29 June 2016

SF2012/002625; WST12/00018/03

**SSD-5157: Lots 1, 6 and 7 DP 752879, Lot 20 DP 250872 and Lot 7300 Section 11 DP 56652;
Gilgai Road, Miandetta; Nyngan Scandium Mine Project**

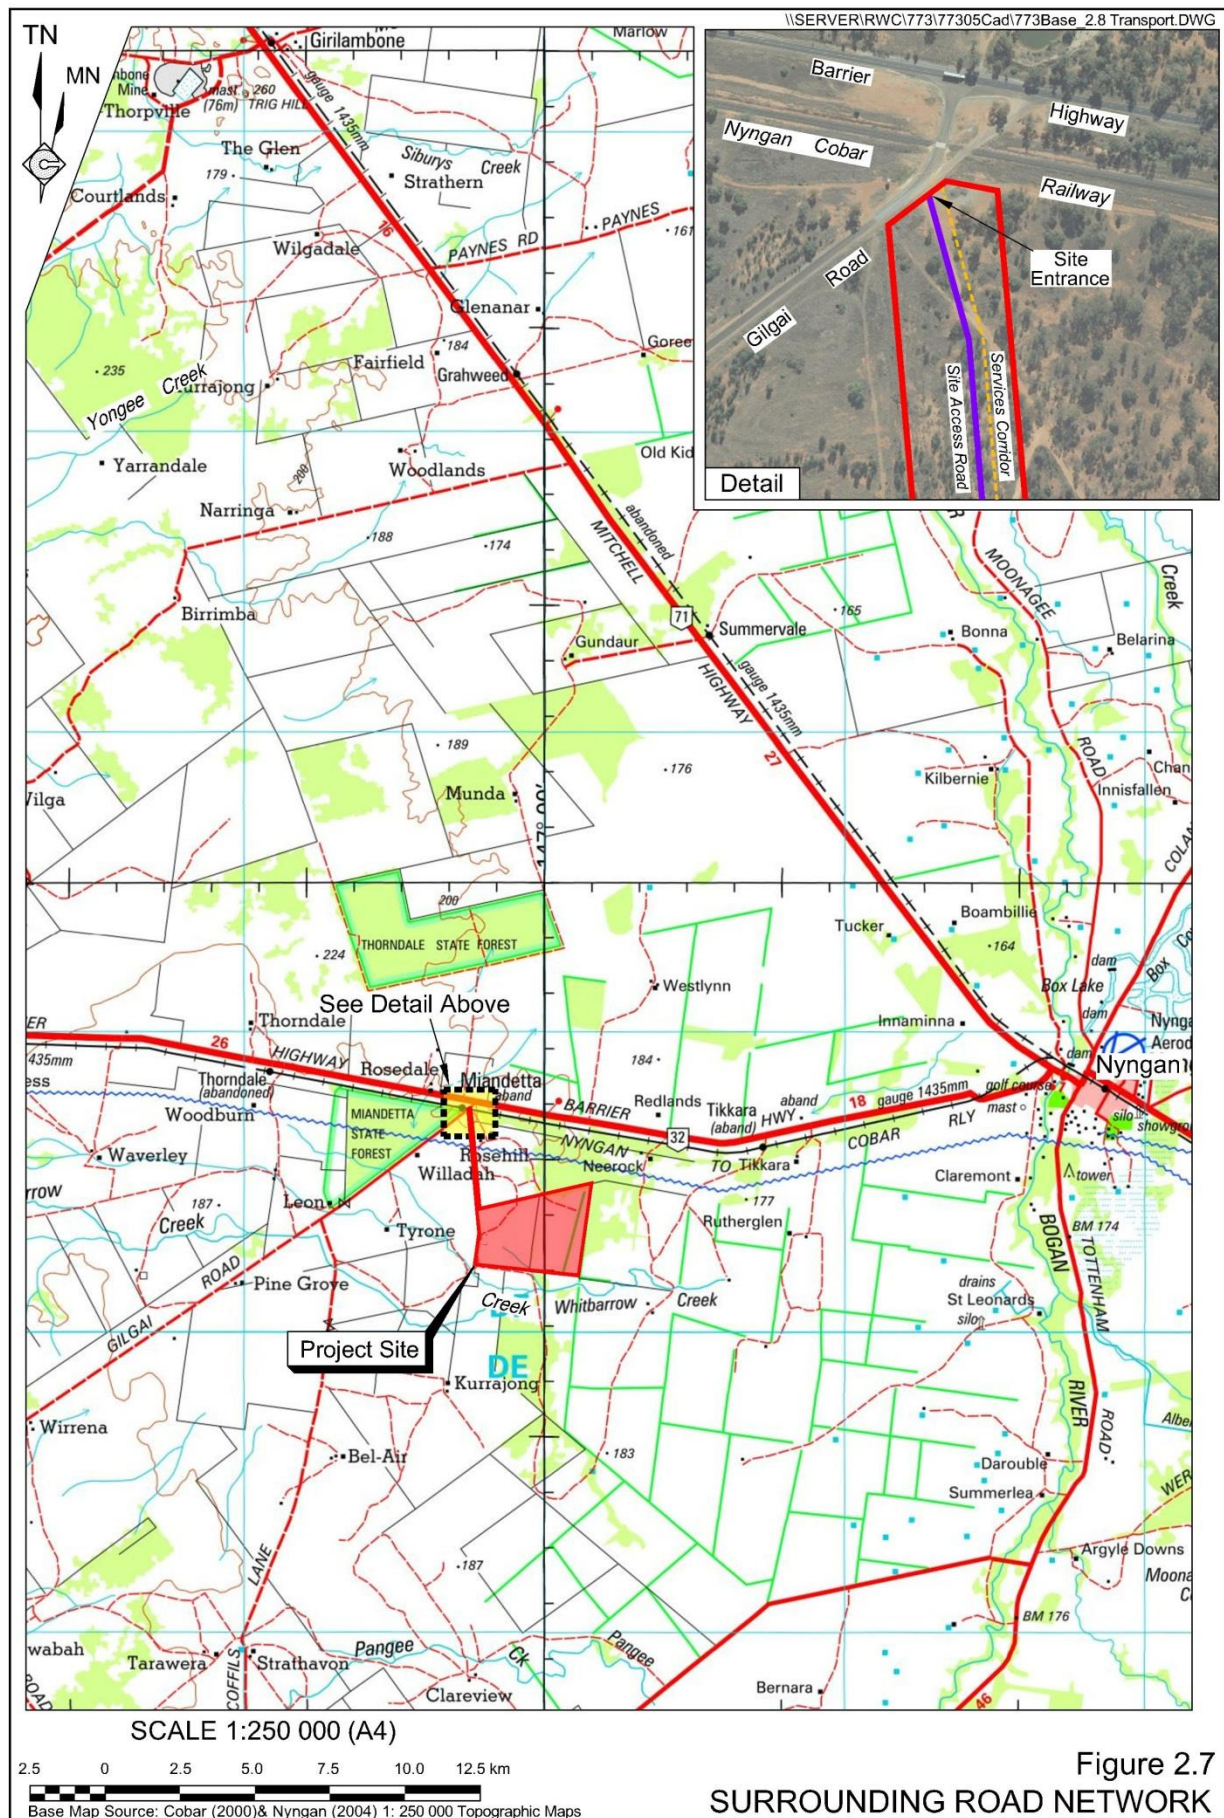
Sight distance at the intersection of Gilgai Road and the Barrier Highway is 200 metres towards the west and 700 metres towards the east. For a 110km/h speed zone, to achieve Safe Intersection Sight Distance (SISD), Roads and Maritime requires 300 metres sight distance in each direction.

The existing intersection of Gilgai Road and Barrier Highway will not be able to safely accommodate additional traffic generated by the proposed development. In particular, there is inadequate sight distance to the west for vehicles turning right from Gilgai Road into the Barrier Highway. The proposed development will significantly increase traffic on Gilgai Road, and significantly increase the occurrences of vehicles performing this turning movement.

The applicant needs to provide additional information demonstrating how a high level of safety can be provided at this intersection for motorists. The additional information needs to include:

- Further analysis and investigation of the intersection detailing what works are required to achieve a minimum SISD of 300 metres at the intersection. If the works required to achieve SISD are unfeasible, alternate measures to achieve a high level of safety need to be provided. The installation of advance intersection warning signs alone are not a sufficient measure and other measures such as lighting and an acceleration lane for traffic turning right into Barrier Highway may need to be employed.

- A detailed survey of the existing intersection treatment. The Basic Right (BAR) turn treatment on the Barrier Highway needs to be in accordance with Figure 7.5 Part 4A *Austroads Guide to Road Design*. Please note the Barrier Highway at this location is open to 36.5 metre road trains, meaning, the eastbound lane and adjoining sealed shoulder needs to be a minimum width of seven metres. Further, the auxiliary left turn lane needs to be in accordance with Figure 8.3 Part 4A *Austroads Guide to Road Design* (copies are enclosed). Any upgrade to the existing intersection needs to be designed to ensure a minimum distance of 40 metres is maintained on Gilgai Road between the hold lines at the rail level crossing and at the approach to the Barrier Highway.
